# KITTITAS COUNTY FIRE MARSHAL'S OFFICE

Re: Littlefield (VA-14-00002)

After conducting a review of the recent changes to the above named project, I have the following comments:

Site Plan

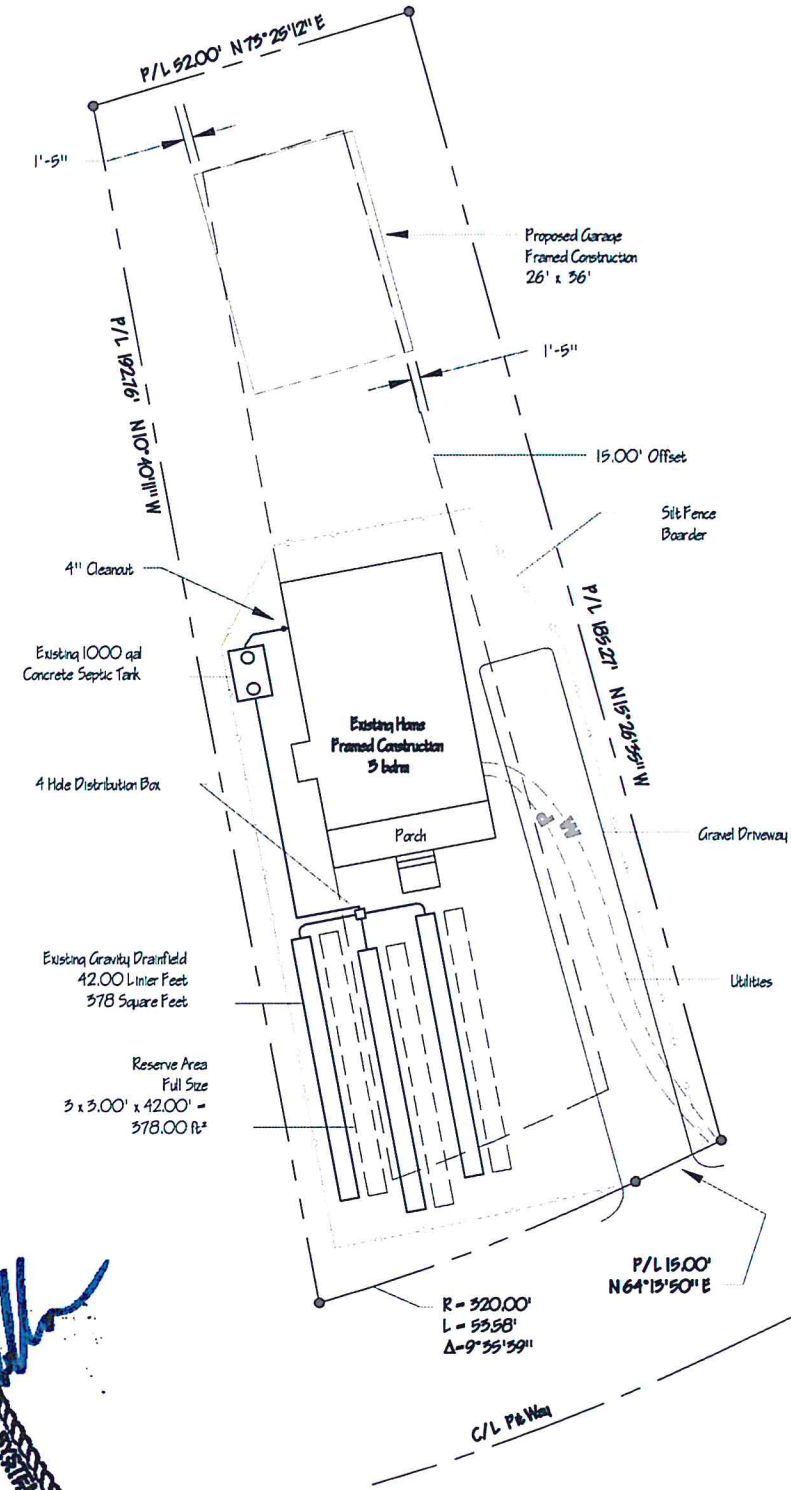
- Ensure that building is constructed so that there truly is just one foot extension into the setback.
- The structure will need to meet the WUI code requirements.
- All future development must comply with the International Fire Code.
